Traffic Impact Study

Caliber at Constitution

El Paso County, Colorado

The Garrett Companies, Inc.

CALIBER AT CONSTITUTION
EL PASO COUNTY, COLORADO
2021 EXISTING TRAFFIC VOLUMES

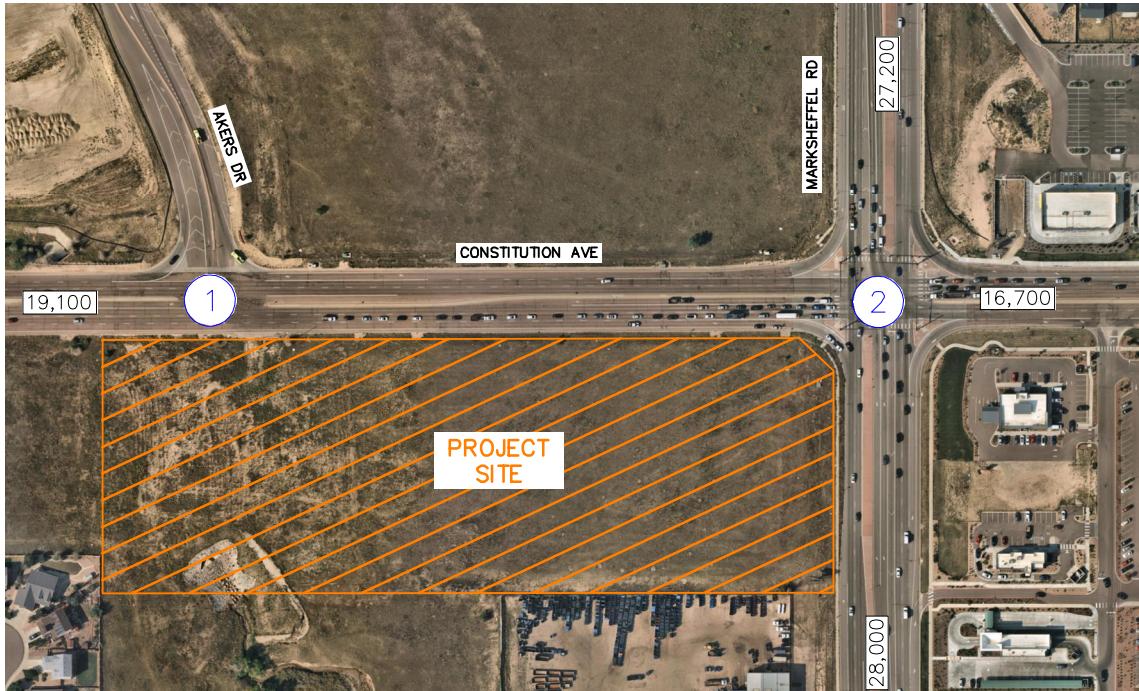
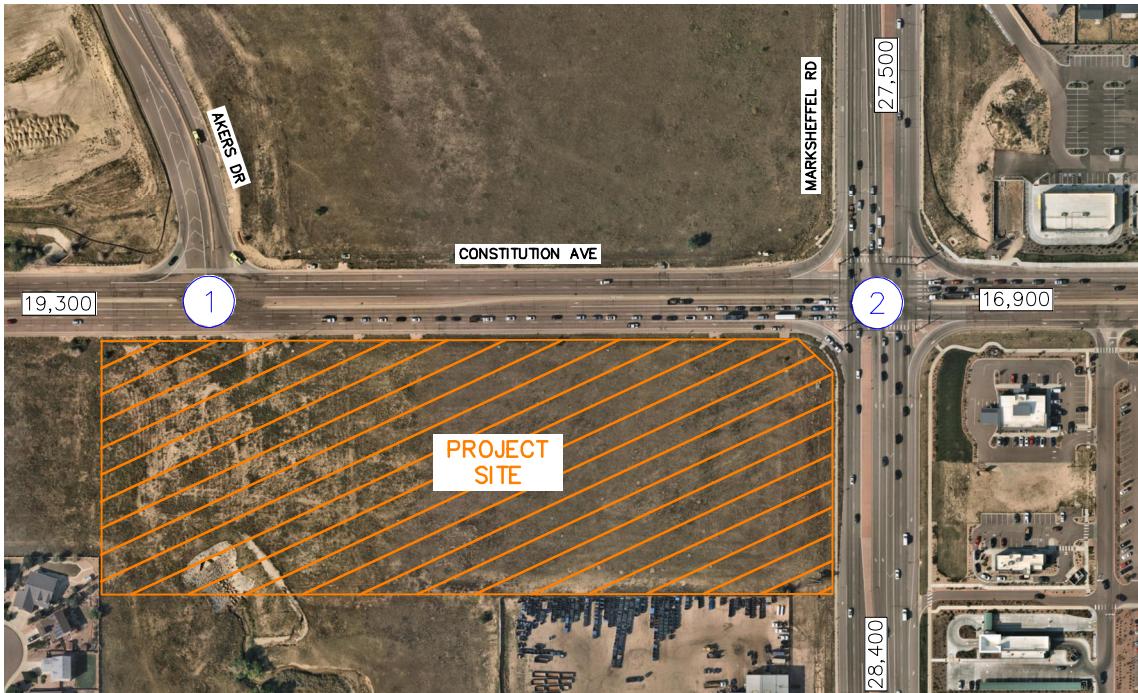
Where did u-turns get accounted for?

U-turns have been evaluated in the revised traffic study and have been included as left turn movements on the traffic volume figures.

CALIBER AT CONSTITUTION
EL PASO COUNTY, COLORADO
PROJECT TRIP DISTRIBUTION

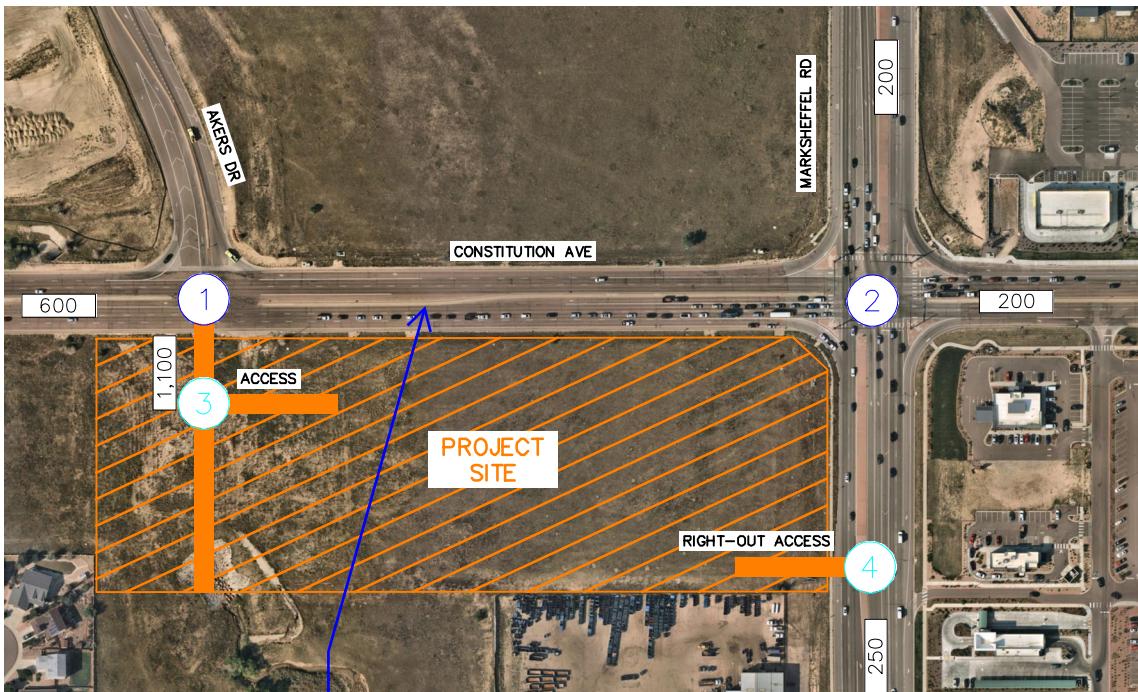
Please elaborate on your reasoning for the distributions shown.

Where did distribution ratios come from?

Additional clarification and reasoning of the development trip distribution percentages have been provided in the revised traffic study.

CALIBER AT CONSTITUTION
EL PASO COUNTY, COLORADO
PROJECT TRAFFIC ASSIGNMENT

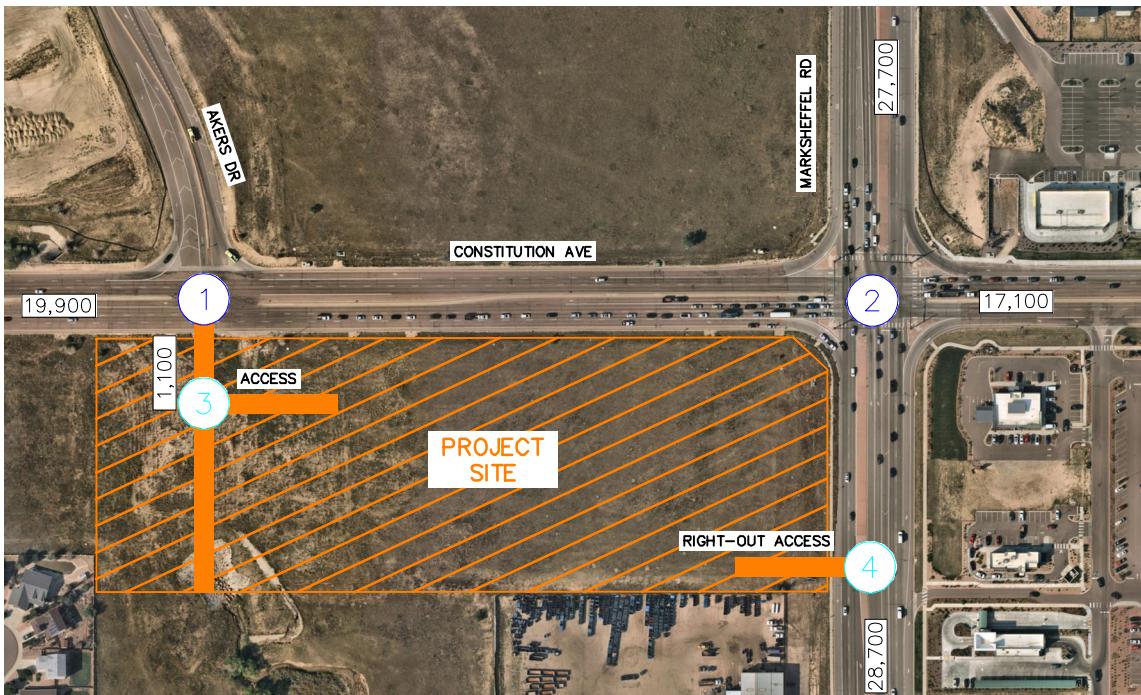
Where/How were these volumes obtained? Can't find any information in appendix to compare with.

Traffic assignment volumes are obtained from multiplying the project trip distribution percentages to the project trip generation. The external ADT volumes add up the daily trip generation volumes shown in Table 1. The entering and exiting turning movement volumes at the accesses add up to the peak hour trip generation volumes in Table 1.

An ADT has been provide on Constitution Avenue east of Akers Drive in the revised traffic study.
